Development Application No.: SSD-10-444  
Description of Development: Blue Gum Community School  
Property: Lot A DP 327582  
1 Rosemead Road, Hornsby

Thank you for the opportunity to comment on the Environmental Impact Statement for the proposed Blue Gum Community School State Significant Development (SSD-10-444). Council officers have reviewed the submitted documentation available on the Major Projects web portal and the following comments are provided for consideration by the Department.

### ***Heritage Assessment***

EXTERNAL STORAGE DETAIL PLAN

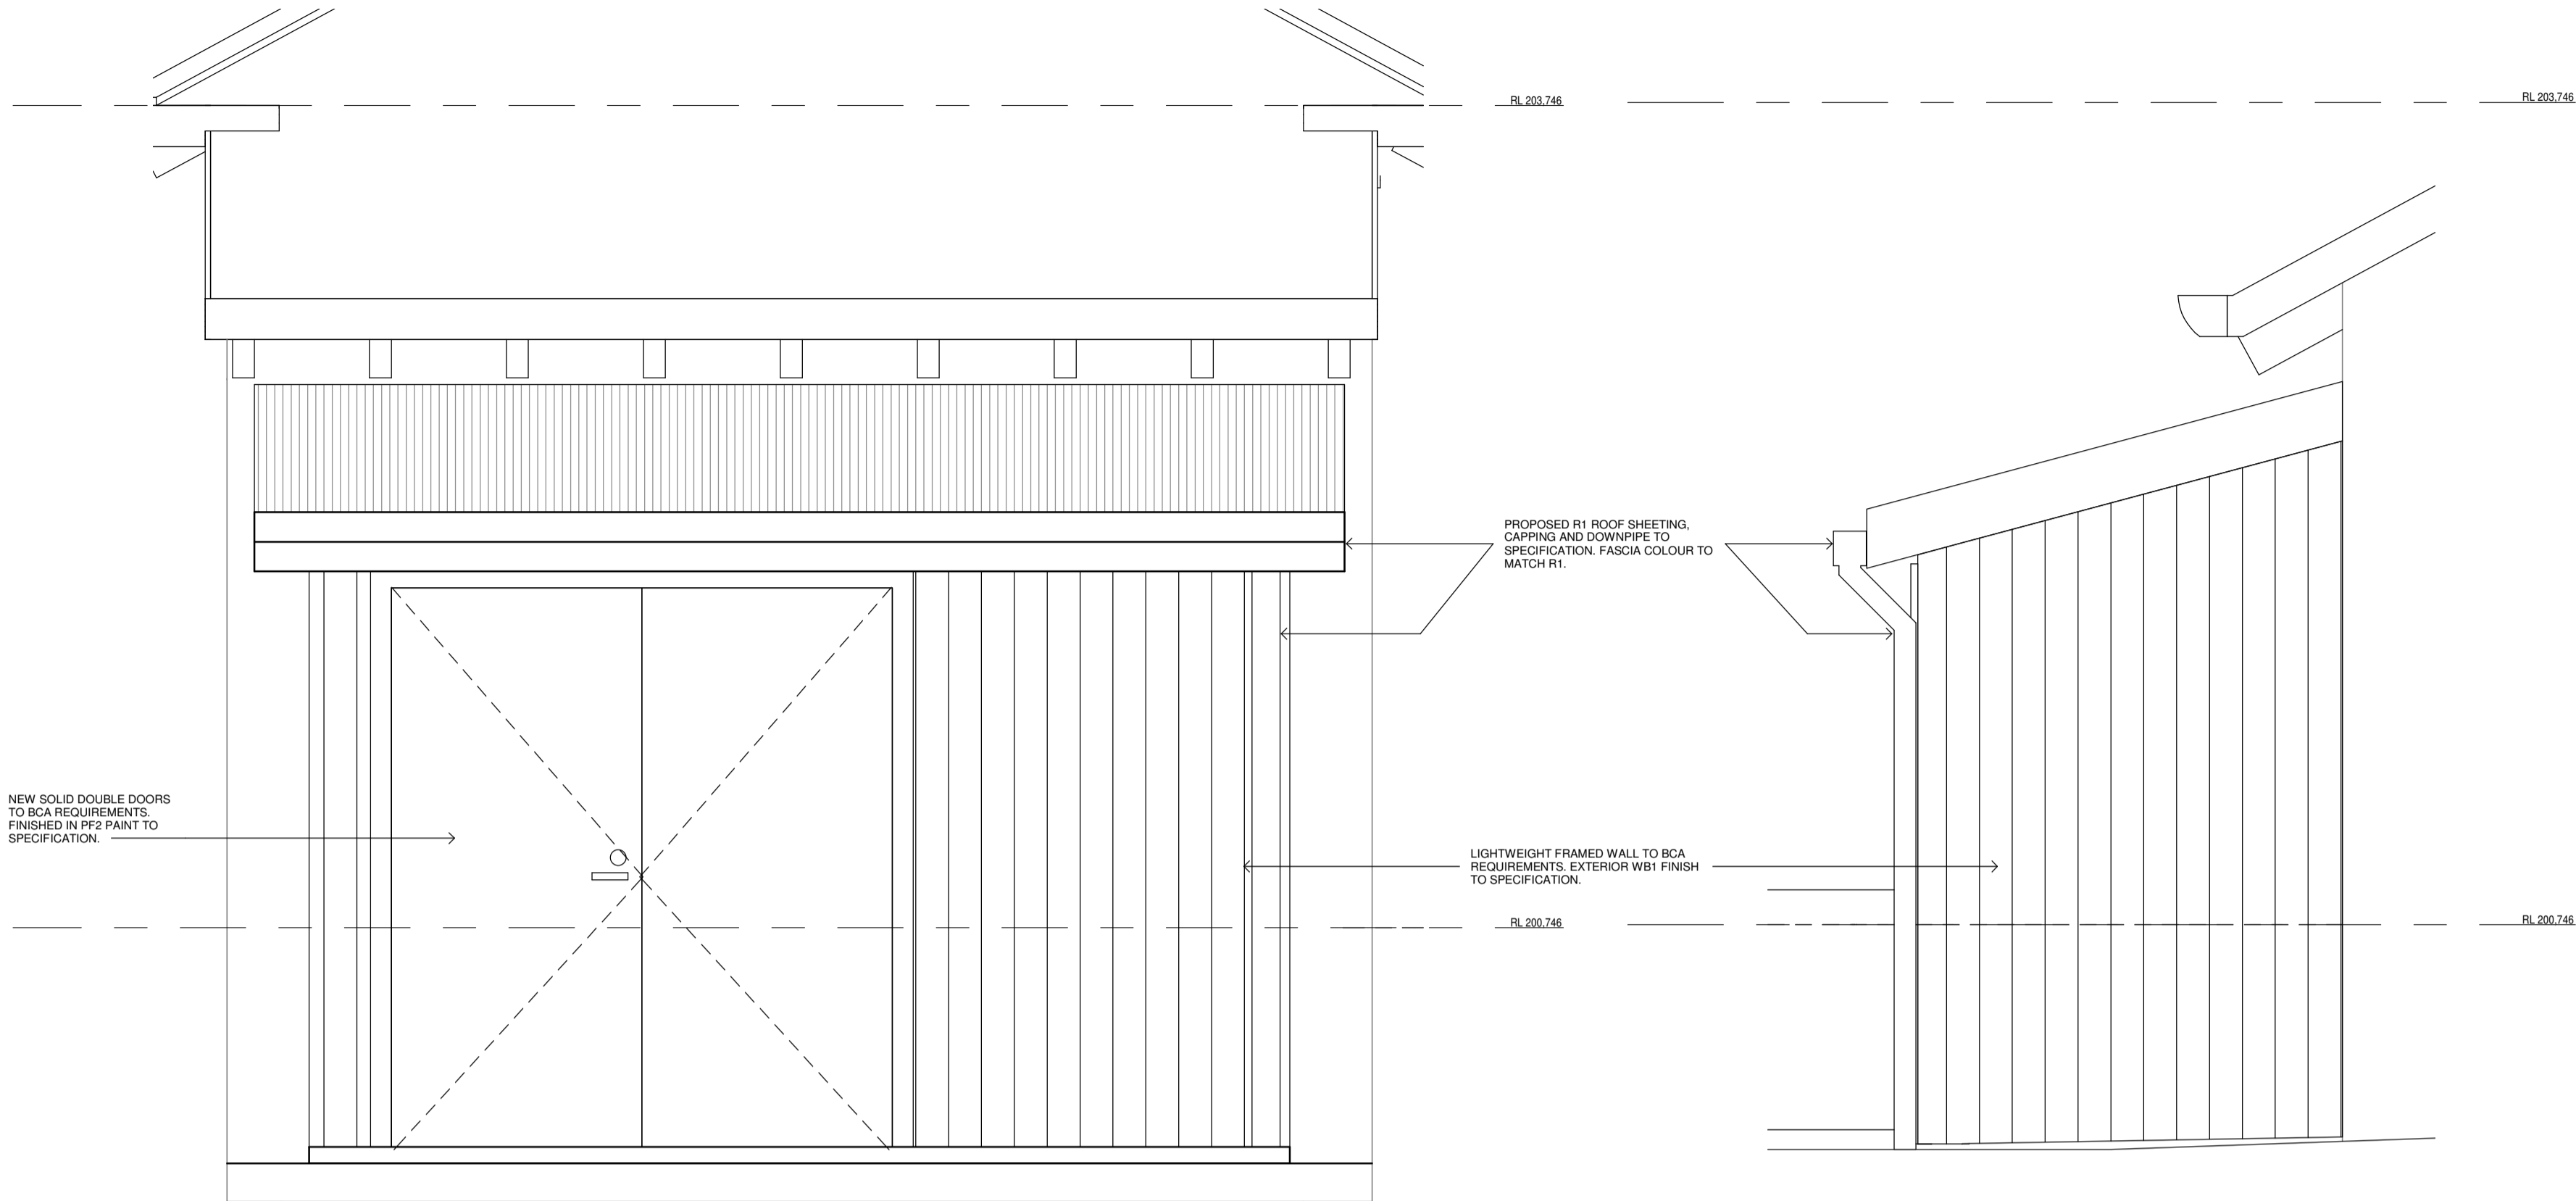
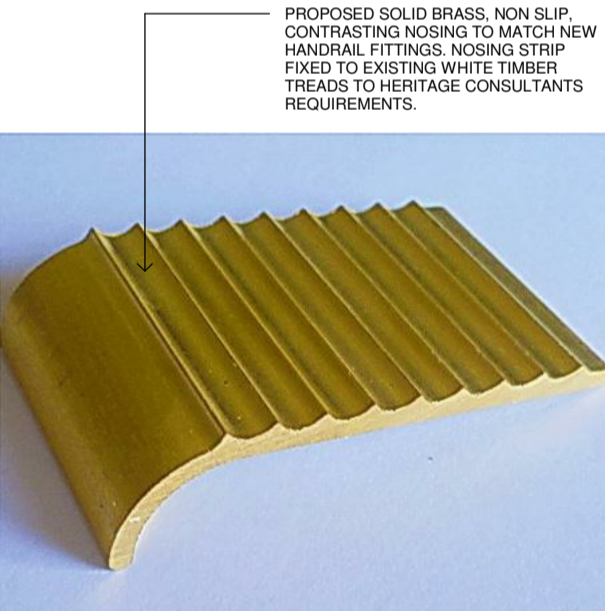
| <b>Proposed Works</b>            | <b>Impact</b>  | <b>Comment</b>   |
|----------------------------------|----------------|--|
| 21.New outdoor storage enclosure | Minimal Impact | <p>This is a small skillion addition to the rear elevation. It is minor and reversible to service the needs of the new occupants of the site.</p> <p>No objections are raised to the modern cladding, double door or colorbond roof as specified on the additional detail plan. The walls are a contemporary interpretation of traditional timber cladding, the dark paint finish is a recessive background colour and the metal sheeting complements the dark slate roof.</p> <p><b><i>The new work complies with Section 9.2.1 Desired Outcomes (a) and (b); Prescriptive Measure (c).</i></b></p> |

MAIN STAIR HANDRAIL DETAIL PLAN

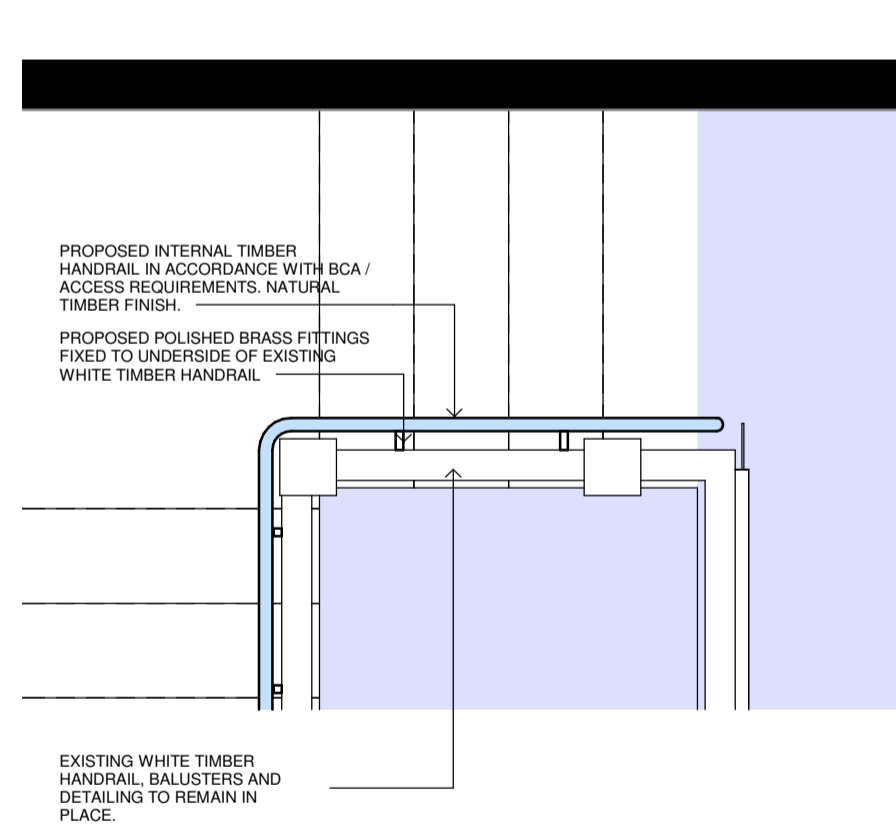
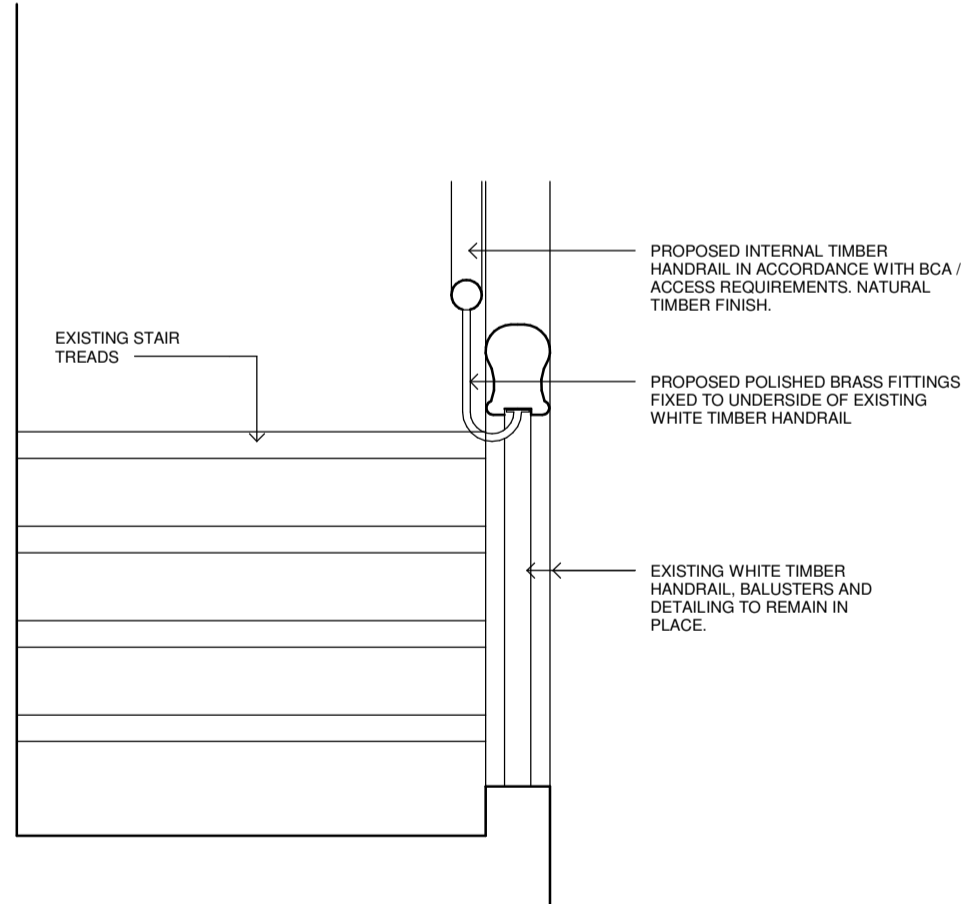
| <b>Proposed Works</b>   | <b>Impact</b>  | <b>Comment</b>   |
|---|----------------|--|
| 28.Existing Stair – new handrail, non-slip paint finish and nosing detailing        | Adverse Impact | <p>The existing stair and handrail are significant to the distinctive Arts and Crafts features of the dwelling. Whilst the new handrail addition would impact the historical accuracy of the design, visual proportions and integrity of the internal stair, it is a reasonably small and reversible addition required for BCA compliance.</p> <p>The new internal timber handrail is a slimline</p>   |

| <b>Proposed Works</b>                                     | <b>Impact</b>   | <b>Comment</b>   |
|---|---|--|
|   |   | <p>utilitarian addition that would be easily recognisable as a contemporary regulatory requirement. The handrail extension has also eliminated the need to significantly impact the original fabric and proportions of the existing staircase.</p> <p>No concerns are raised with the proposed non-slip paint finish and nosing detailing to match existing to meet the BCA Performance Solution requirements.</p> <p><b><i>The proposal complies with Section 9.2.1 Desired Outcomes (a) and (d); Prescriptive Measures (a) and (g).</i></b></p>  |
